# PORTLAND MAINE

July 3, 2006

RE: 30 Washington Avenue – 013-F-007 – B-2b Zone – permit #06-0951

FOUNDATION PLAN

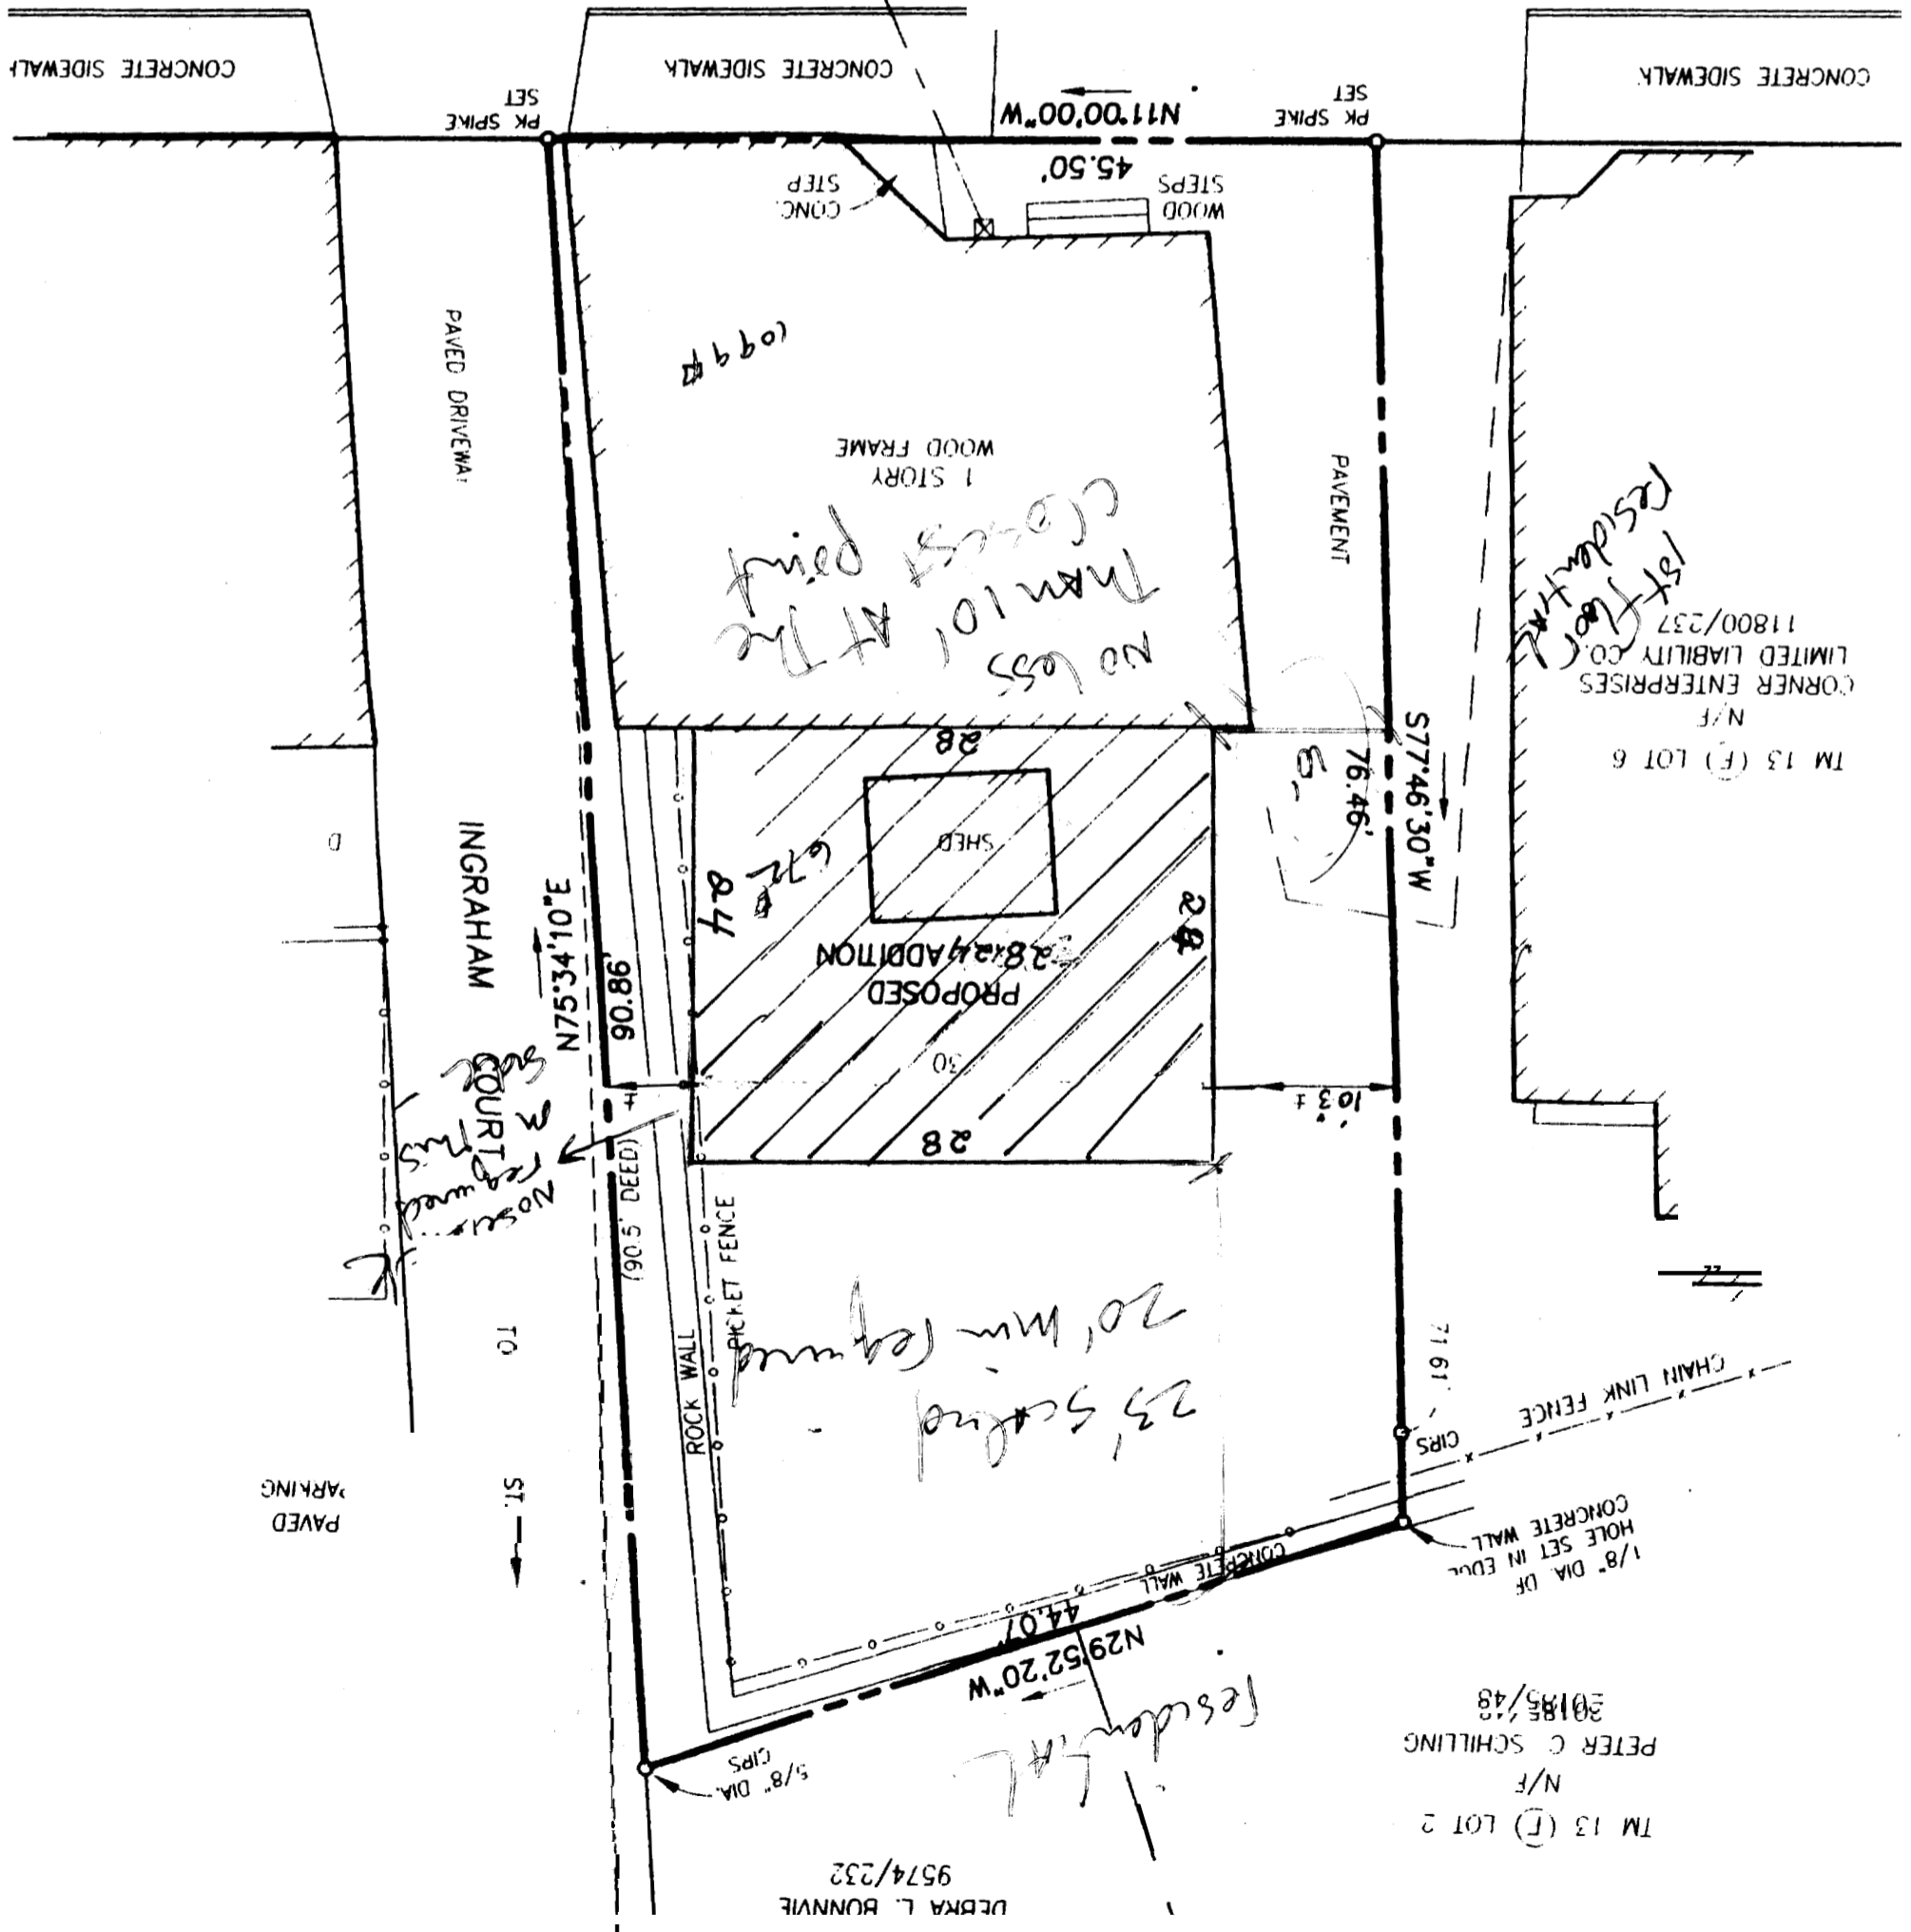
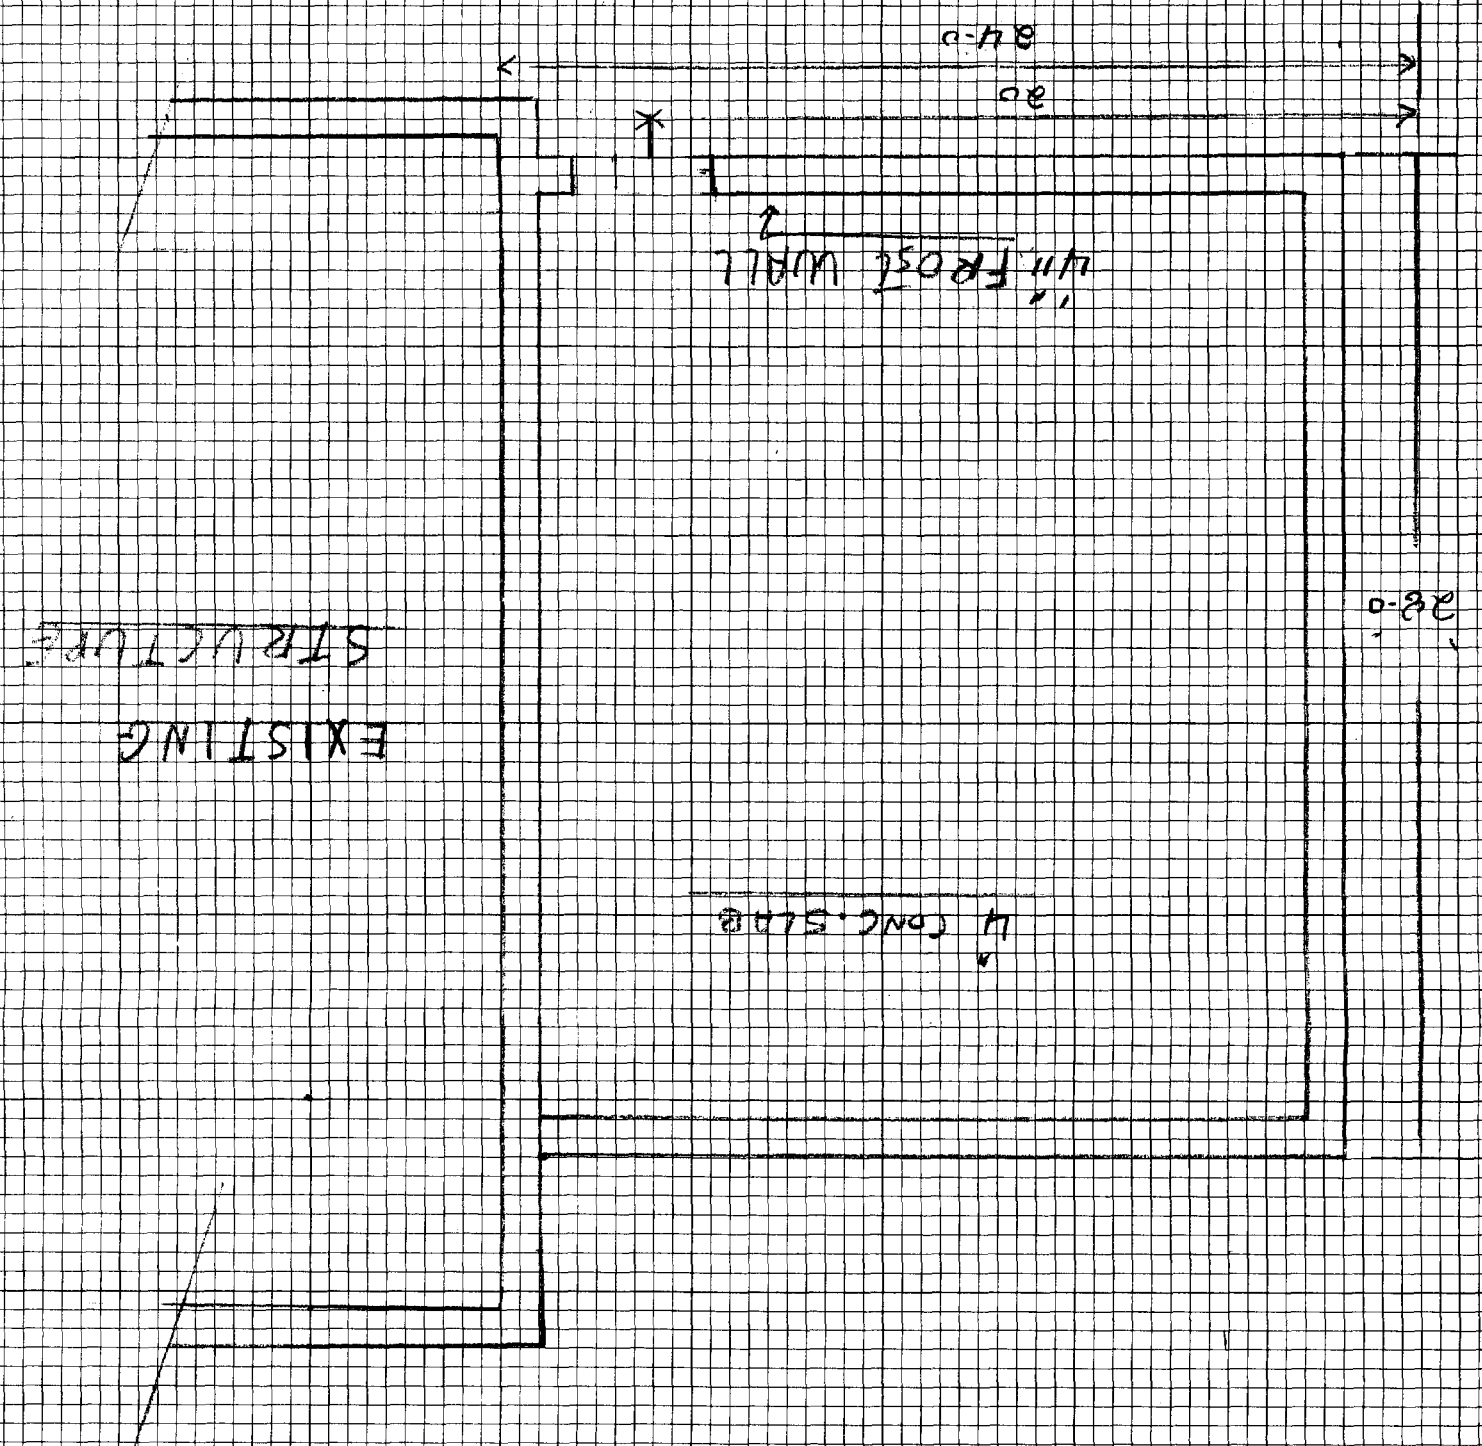
Your application also indicates that you may want to add a 20' x 30' addition onto the rear of the existing building. This addition is not part of your request. It also appears that the new addition would go over the existing property line. Please clarify if this is part of your permit request. If it is not part of your request, it should not be drawn on your application request to eliminate confusion.

There is also confusion regarding the 20' x 30' addition in the rear of the building. This addition already exists. It was built approximately **2** years ago. The previous tenant used this space as a retail space (grocery store). Therefore, building this addition is not part of my permit request because it is already part of the property.

# PARKING DETAIL

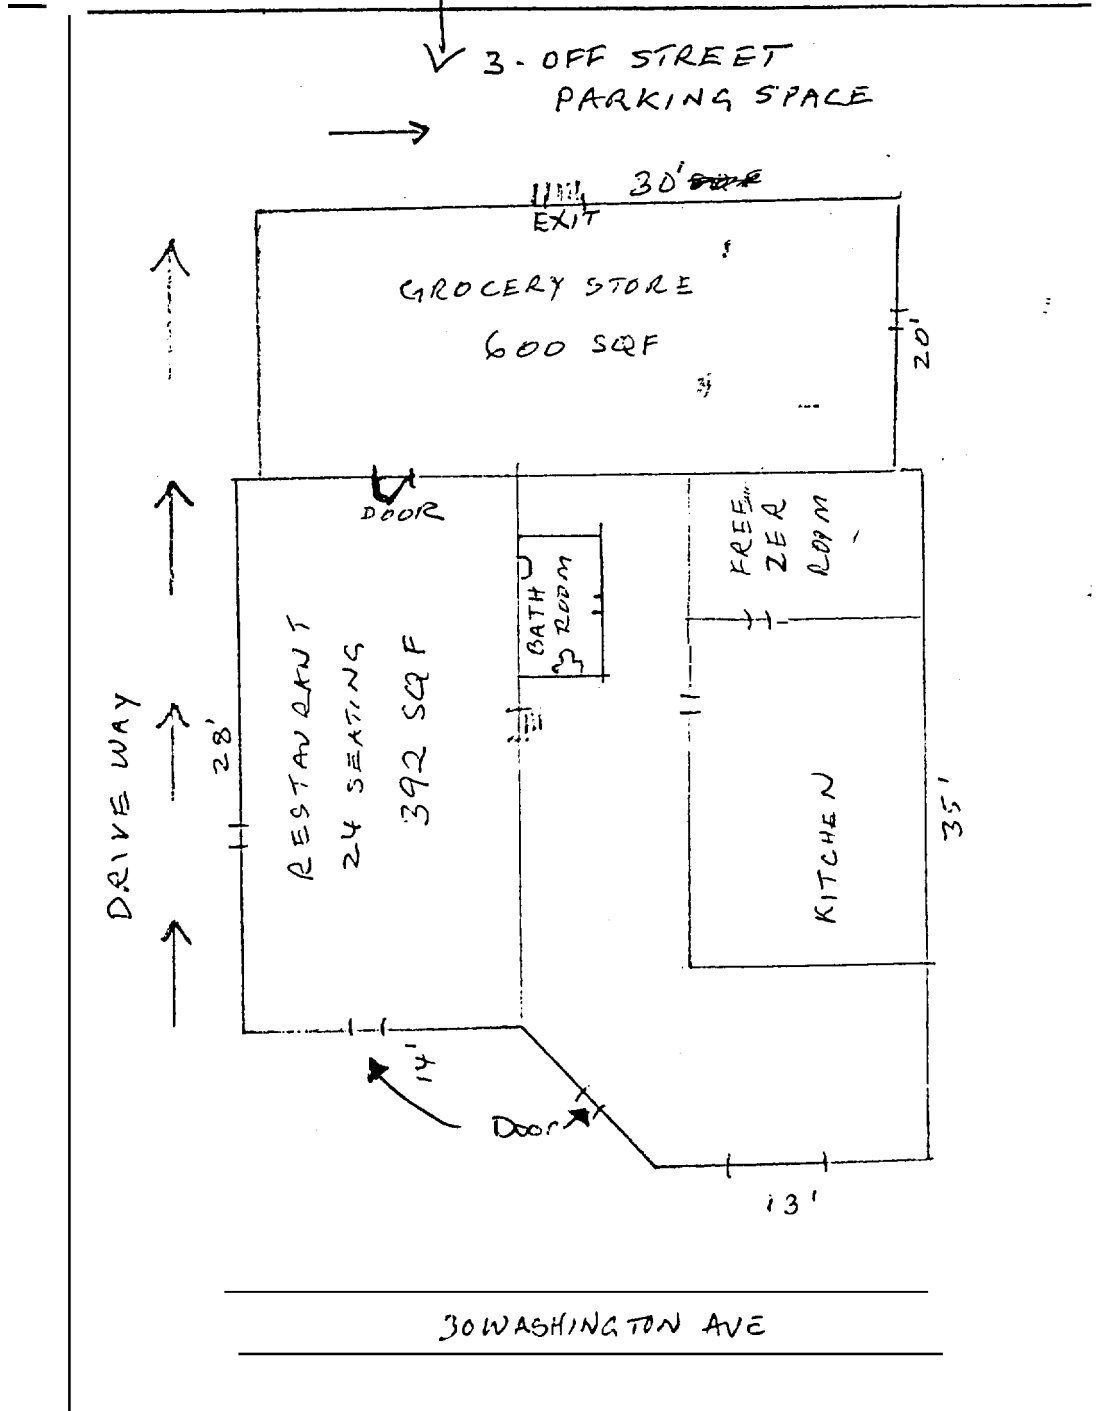
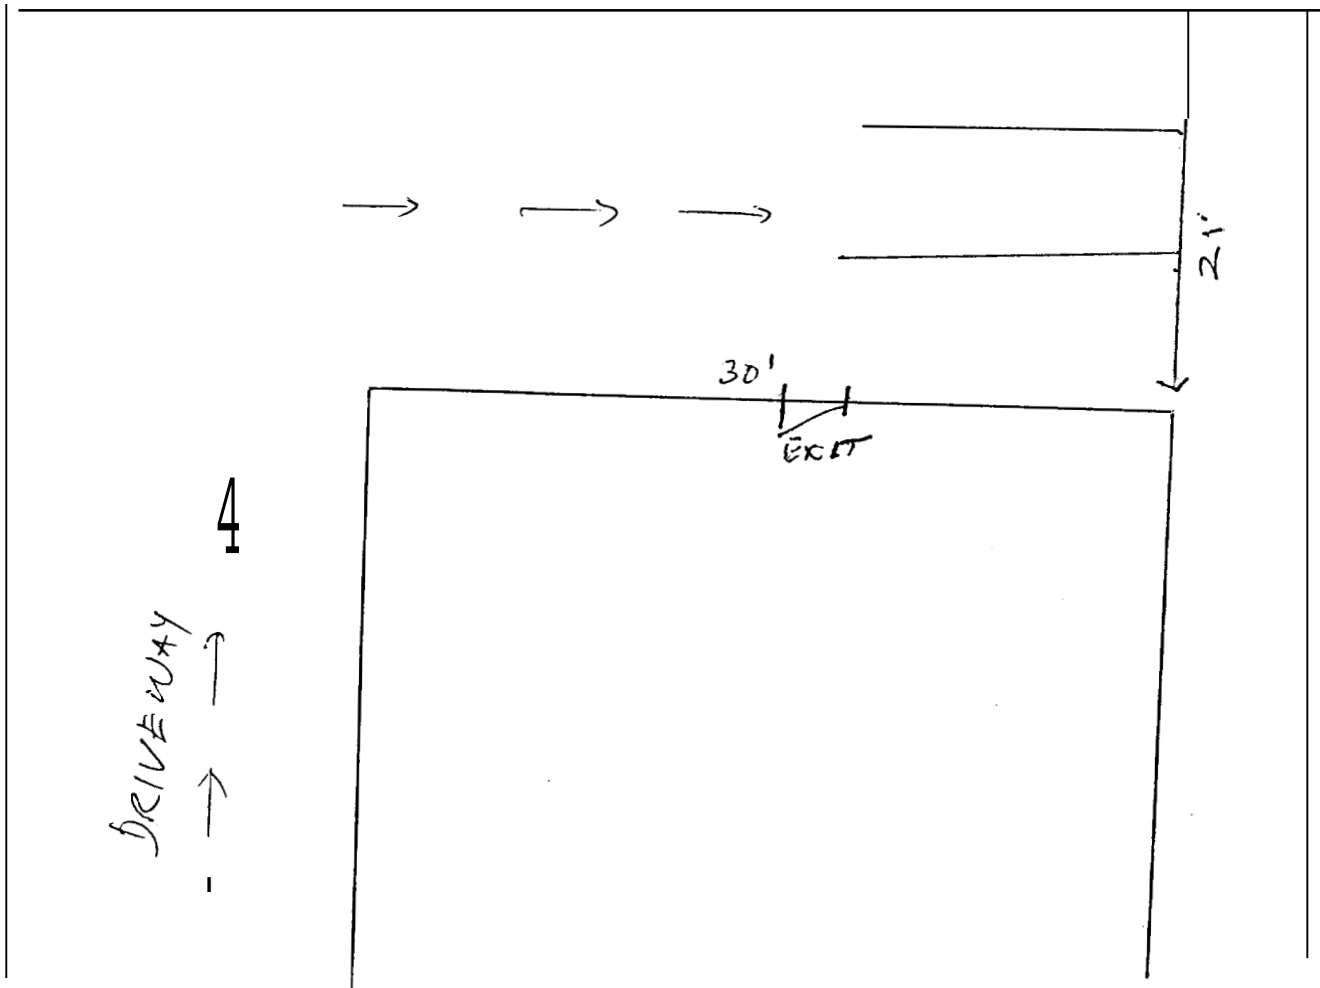
I am in receipt of your permit application to change the use of the property at 30 Washington Avenue from a retail store to a restaurant and a retail store. Your permit is being denied because the new restaurant use requires off-street parking. Your submittal shows no off-street parking, only on-street parking. A restaurant use requires 1 parking space for each 150 square feet of restaurant area. You are showing approximately 400 square feet for the restaurant use. Therefore you must show 3 off-street parking spaces. Better interior floor plans must be submitted for this further review.

I am writing in response to your letter regarding my application to change the use of the property at **30** Washington Avenue. I have included a copy of your letter. I would like to clarify a few of the concerns that you expressed. You mentioned that my submittal showed no off-street parking. However, there are 3 off-street parking spaces behind the property. The landlord of the building was unable to give me a floor plan showing those parking spaces and that is why they weren't included in my submittal.
